415 Cumberland Avenue

415 Cumberland Avenue - Final Traffic Comments

Subject: Application ID: 2018-011

PEZ 2018-011: Building Conversion, 415 Cumberland Avenue

415 CUMBERLAND AVENUE SIDEWALK/DRIVEWAY REPAIRS

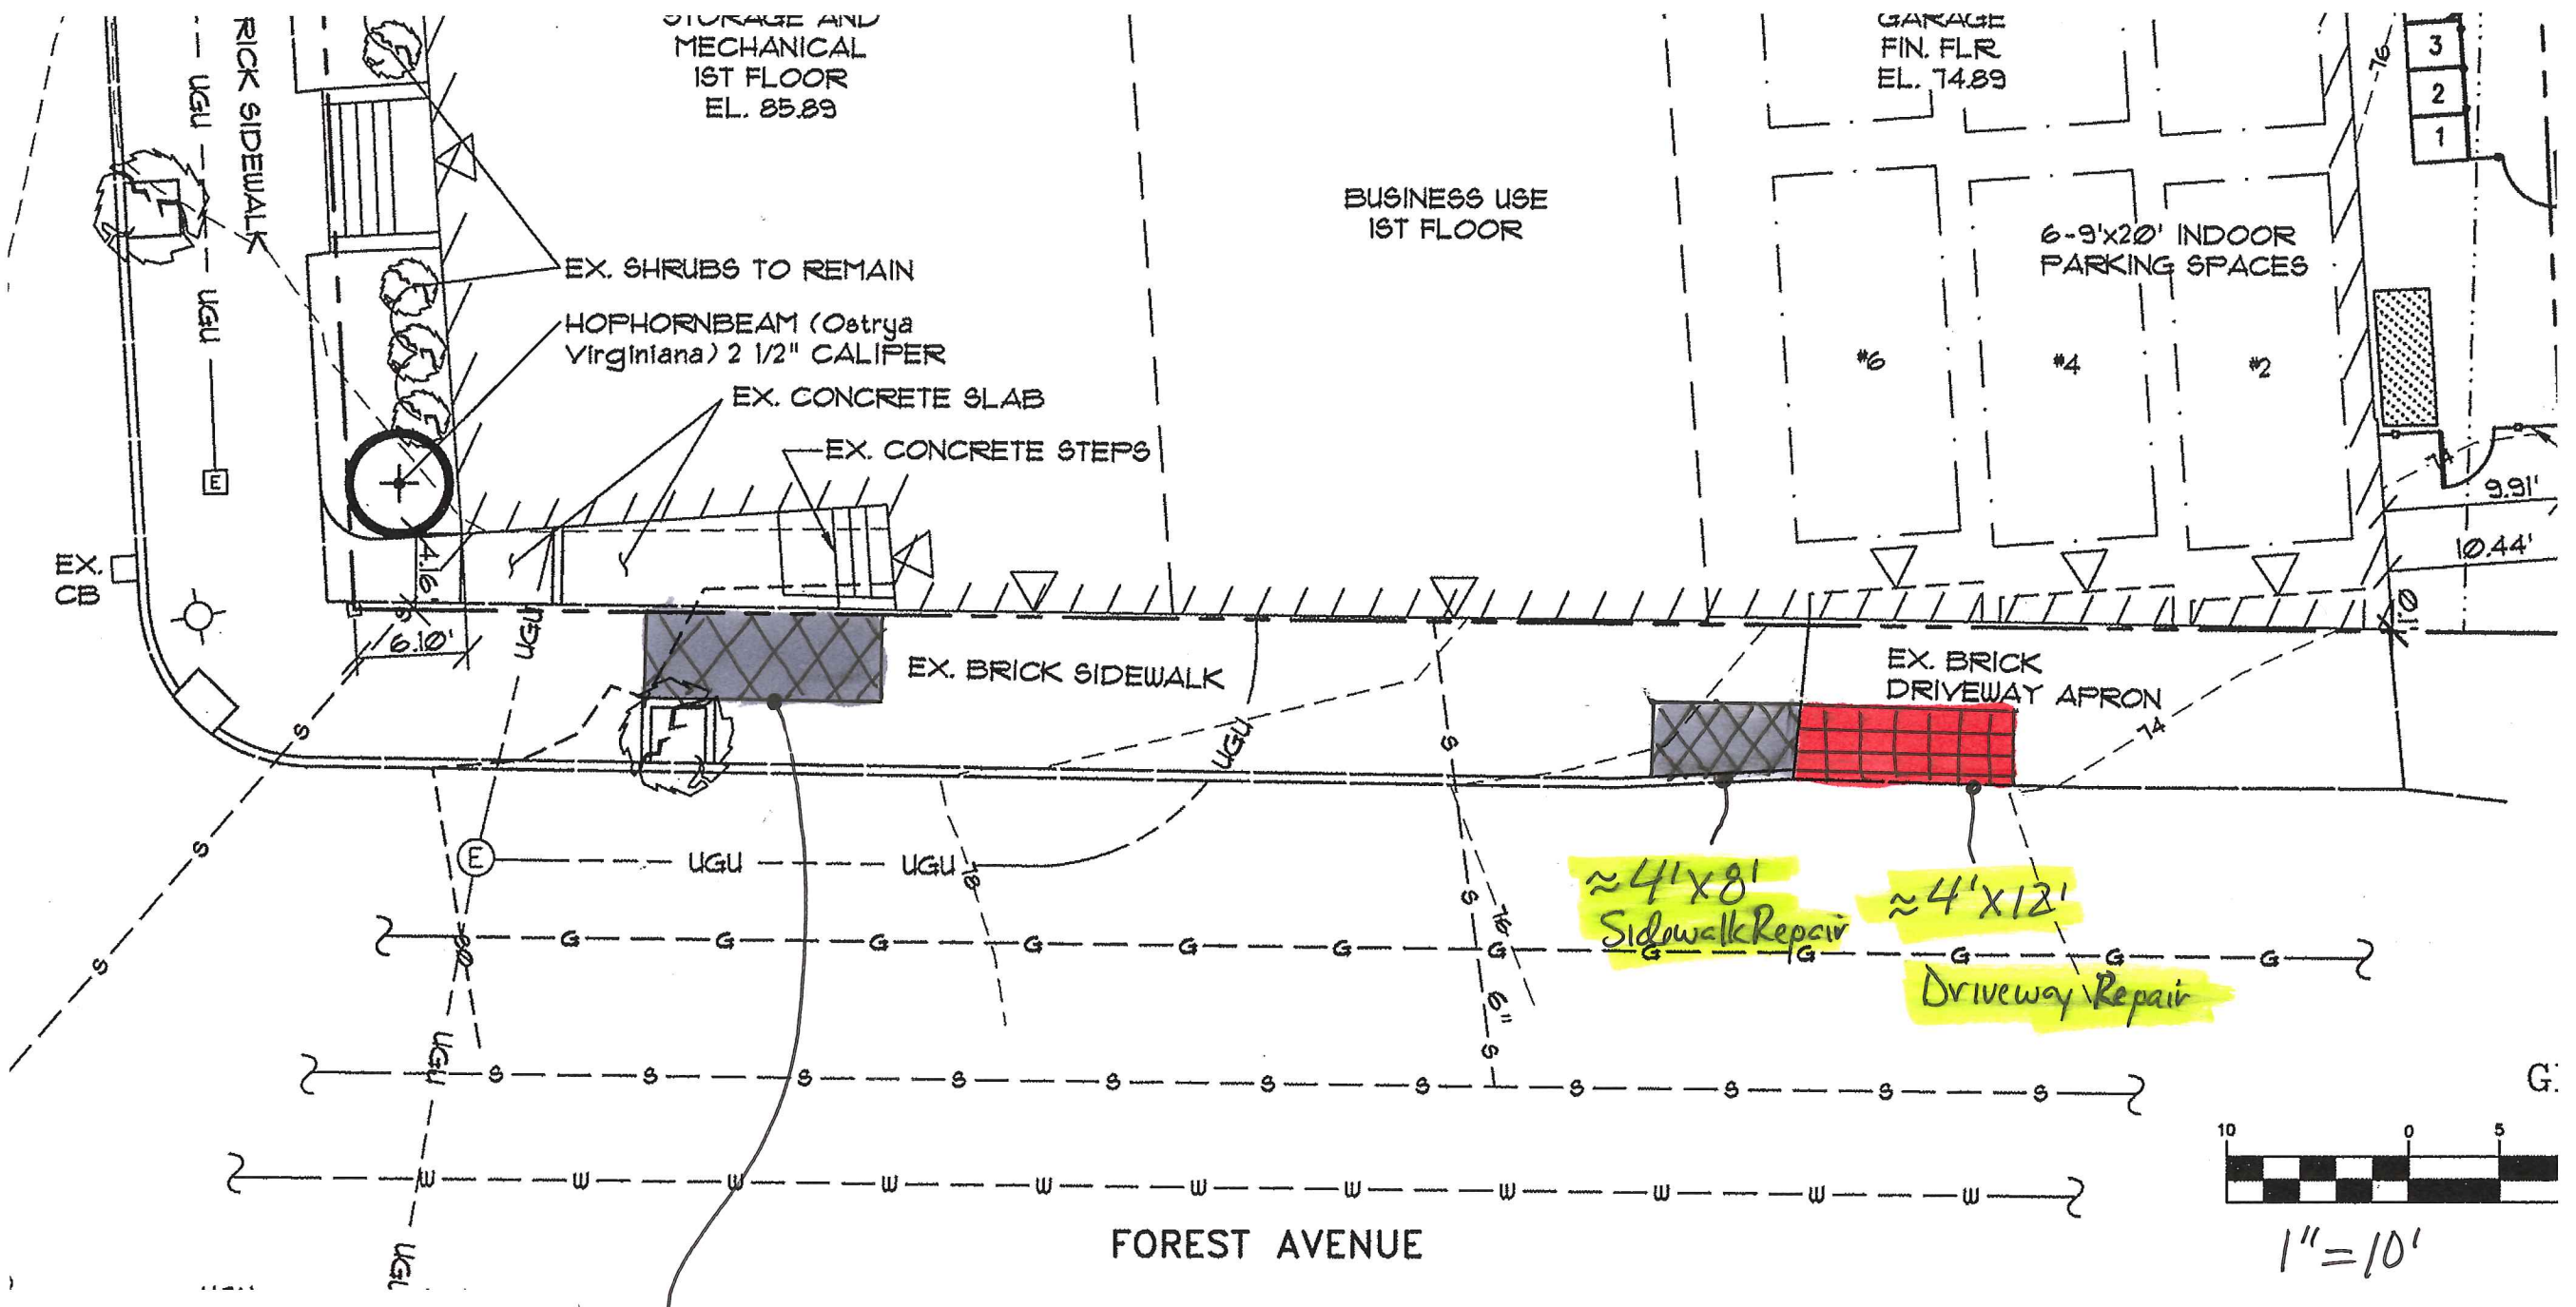
DPW position is that the driveway apron shall be reconstructed in conformance with technical standards. That being said, the apron should match into the existing sidewalk conditions which appear to be in excess of 2 percent cross slope. We do not want a case where the apron is 2% matching into 4-10% grades creating an even steeper grade. We would require existing and proposed grades for analysis.

- the ADA-compliance of the sidewalk and driveway along the project's frontage on Forest Avenue should be confirmed for cross-slope (maximum 2% cross-slope for a minimum of 5' of width) and condition.

Sheet Title:
SITE PLAN

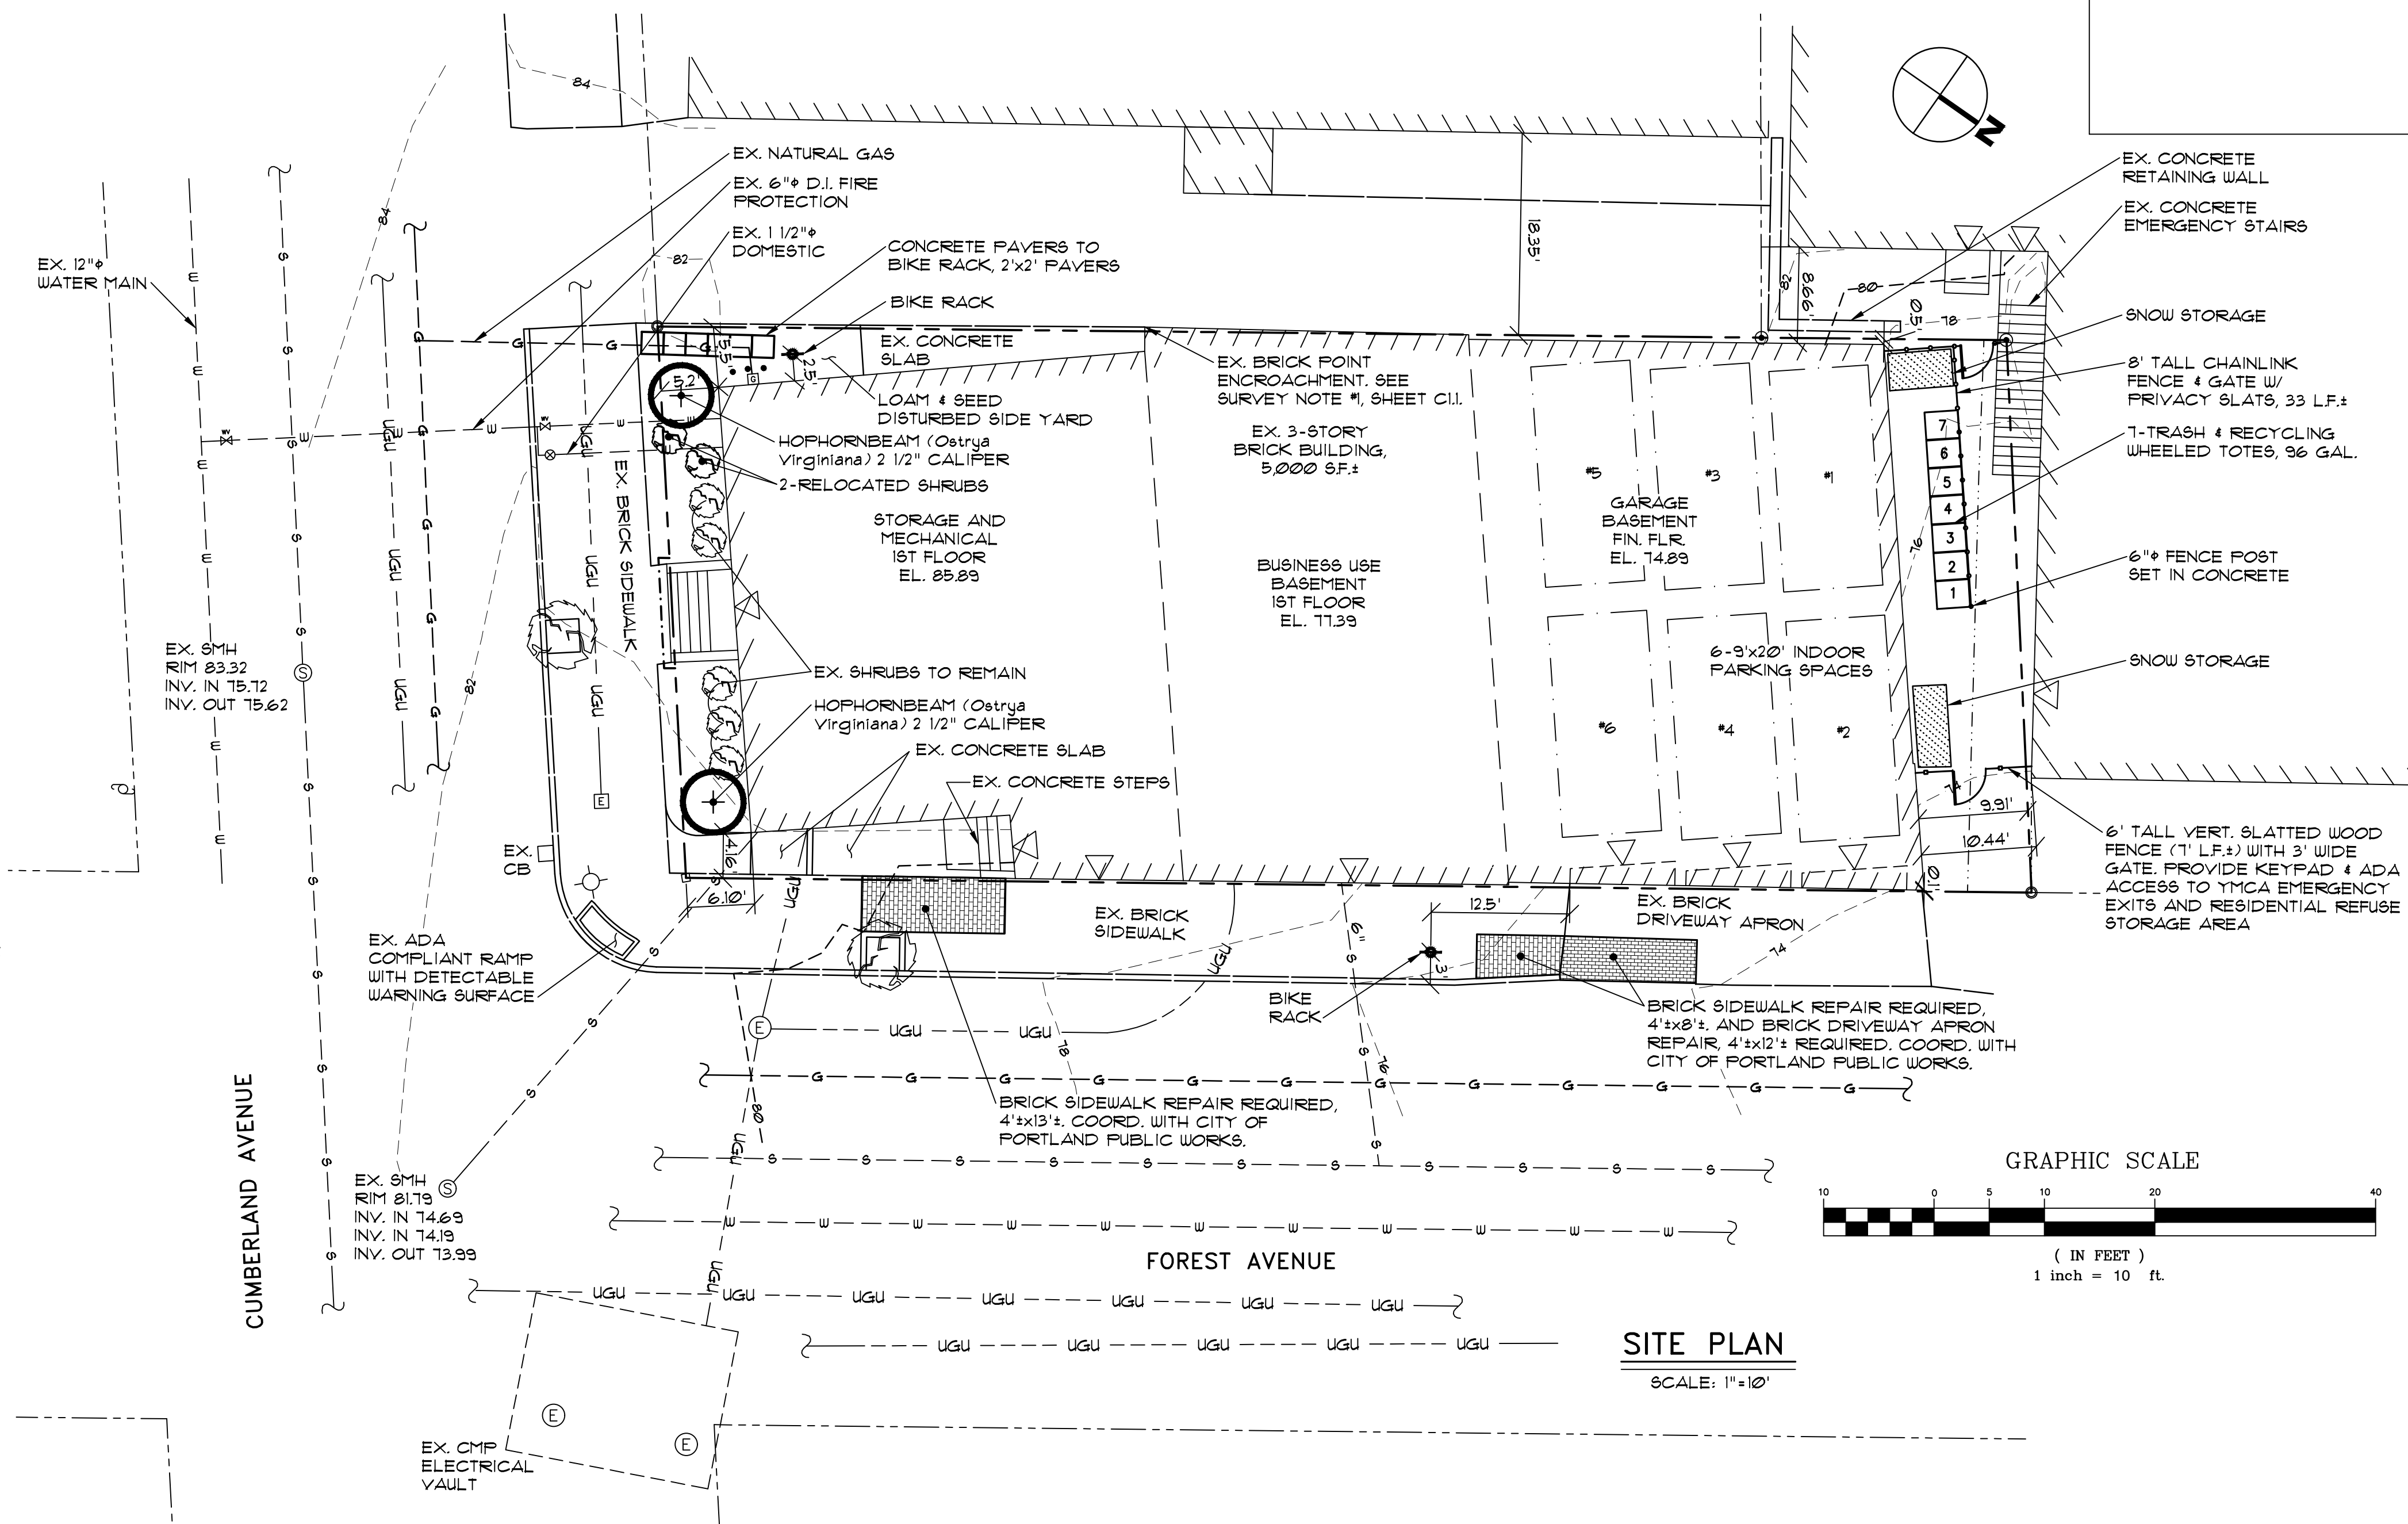
- The tandem parking spaces shall be designated for the residential units only (or for low turnover use) to ensure that backing maneuvers onto Forest Avenue are minimized given vehicle and pedestrian traffic levels.

- Street view identifies that there is a tree in the sidewalk on Cumberland Avenue. The plan doesn't show that it exists and/or is being removed.
- The existing ADA ramp at the corner is shown in sort of an odd way – the curb line should be drawn to show the location of the ramp tactile warning strip.
- The light pole shown on the subdivision plat is a traffic light pole with a mast arm. I'm not sure if the plat should identify that.
- The plat shows the ROW line on Cumberland crossing features out of the sidewalk (bottom step and the mulch planter areas). I'm assuming that is the existing condition, but I'm wondering if that needs to be addressed on the plat.
- At the southern corner of the building (plan northwest corner), they are showing a new walkway of pavers. This crosses the sidewalk, and I'm guessing that wouldn't be acceptable to the City.

- the curb ramp is to be updated to achieve full ADA-compliance and meet existing Technical Standards - I've attached the curb ramp configuration provided to the previous applicant's project team for this location - the current standard for the detectable warning panel within the curb ramp is cast iron with a 4" concrete border and is available from DPW if needed

- the layout and dimensions for the 2 bicycle racks need to be checked for adequacy - the minimum clearance (O.C) are: from the building, 30"; between racks is 36" and from the edge of the driveway is 24". Sufficient clearance from the exterior gas service and bollards also need to be considered. It appears the bike racks would also block access to the external stairway from the 2nd floor without going onto the adjacent property. Other locations on-site or within the sidewalk on either Forest and/or Cumberland Avenue can also be considered to make them more functional and not block this access.
